Arun District Council
Arun Civic Centre
Maltravers Road
Littlehampton
West Sussex BN17 5LF
Planning & Building Control General Enquiries
Tel: (01903) 737756 Fax: (01903) 730442
Dx: 57406 Littlehampton
Minicom: 01903 732765
e-mail: planning@arun.gov.uk
website: www.arun.gov.uk/planning

Application No: A/193/20/PL
Site Address: Ham Manor Cottage Ham Manor Way Angmering BN16 4JQ
Description of works: Erection of a 1 No. 3 bedroom chalet bungalow & detached garage. This site is in CiL Zone 3 and is CIL Liable as dwelling.

Thank you for your internet representation made on 31st March 2021 which has been recorded as an objection with the comments as follows:

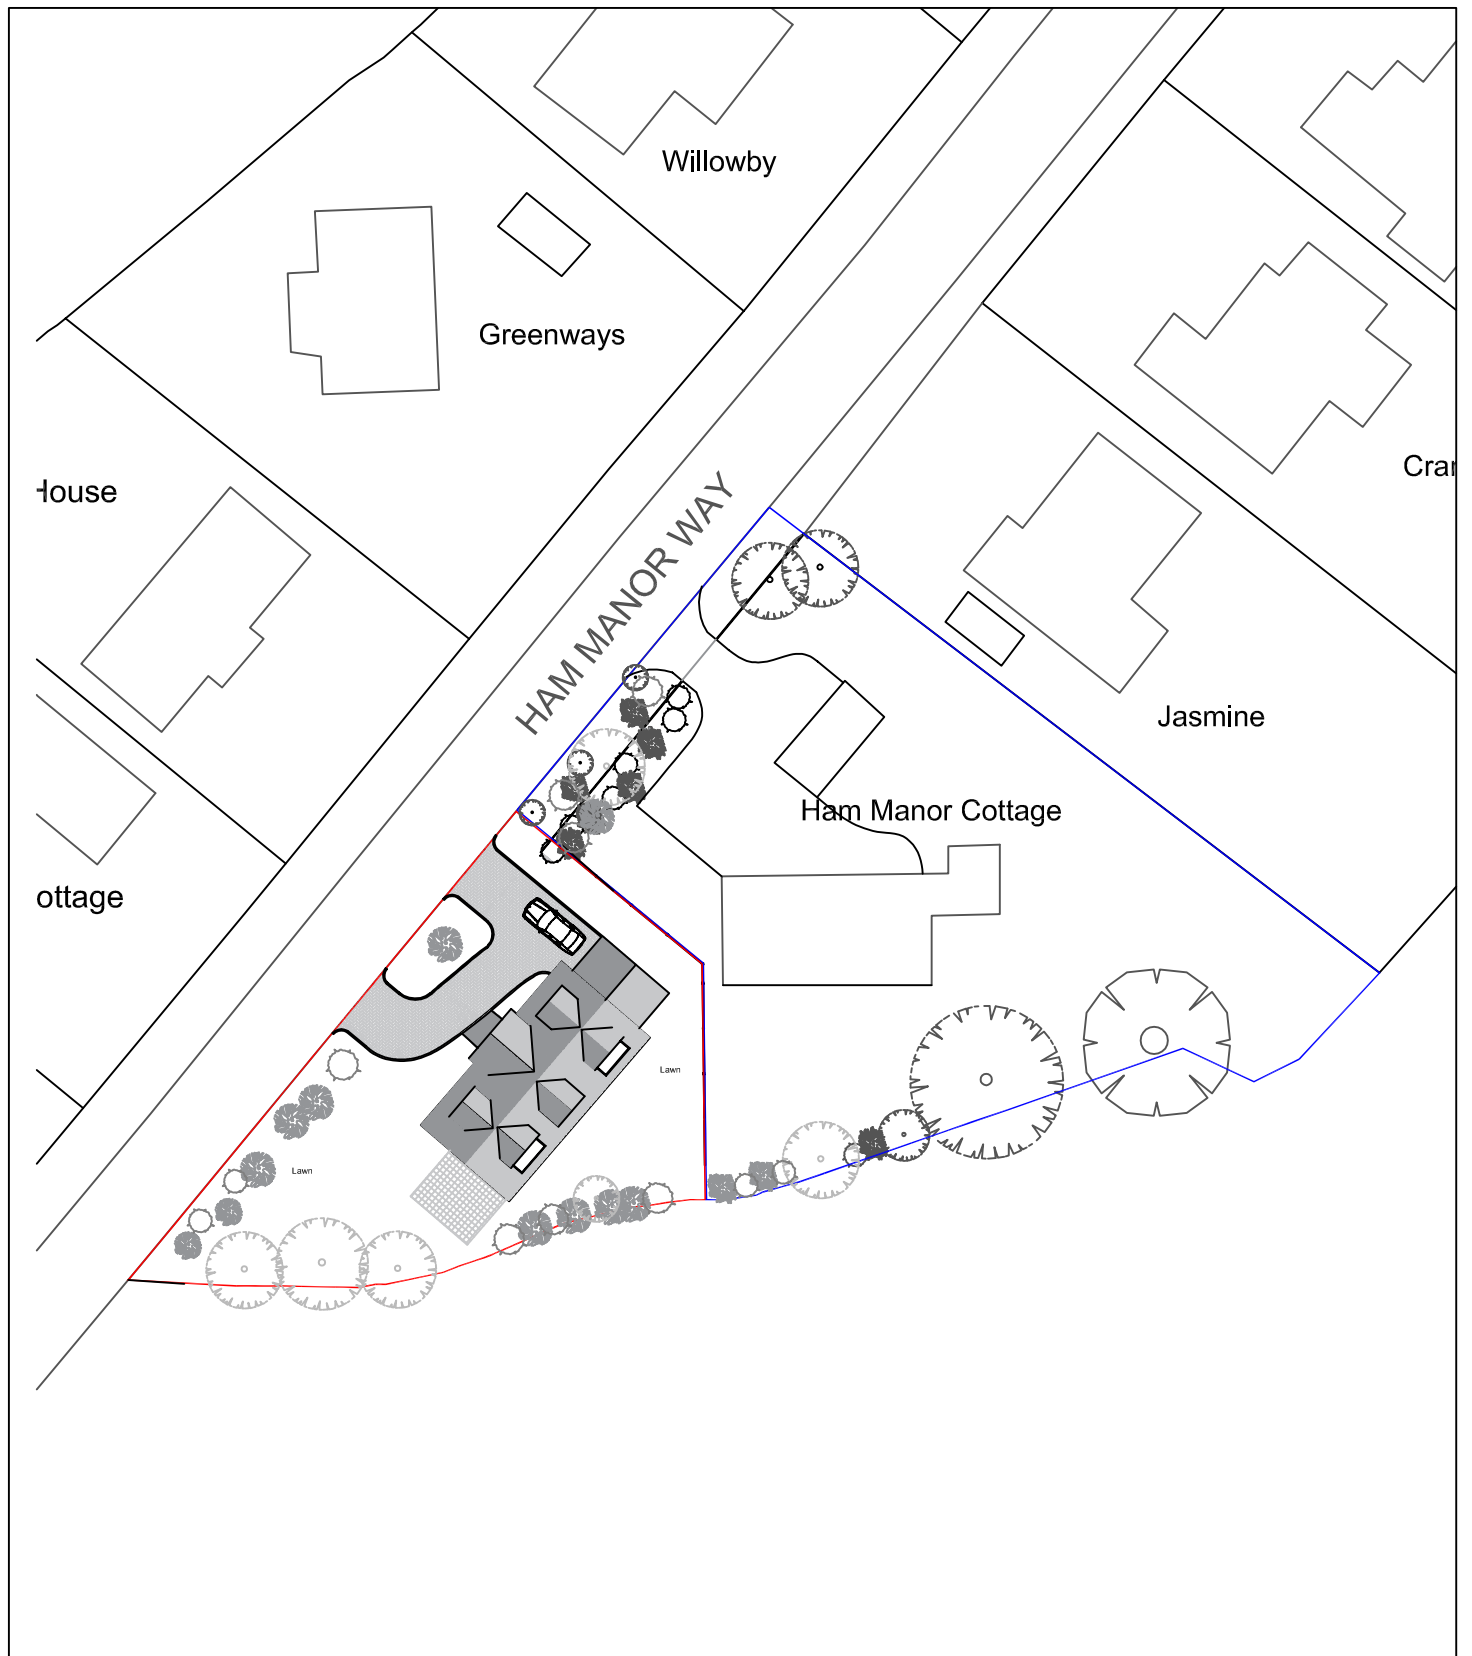
The submitted plans indicate that the majority of the footprint of the proposed dwelling would be in front of the building line of this eastern length of Ham Manor Way. This layout is not characteristic to this area and would conflict with: -

- Arun's adopted Local Plan Policy D SP1
- Arun's Design Guide Section M Pages 114 and 116
- Angmering's Neighbourhood Plan Policy HD5
- Nationally accepted guidelines
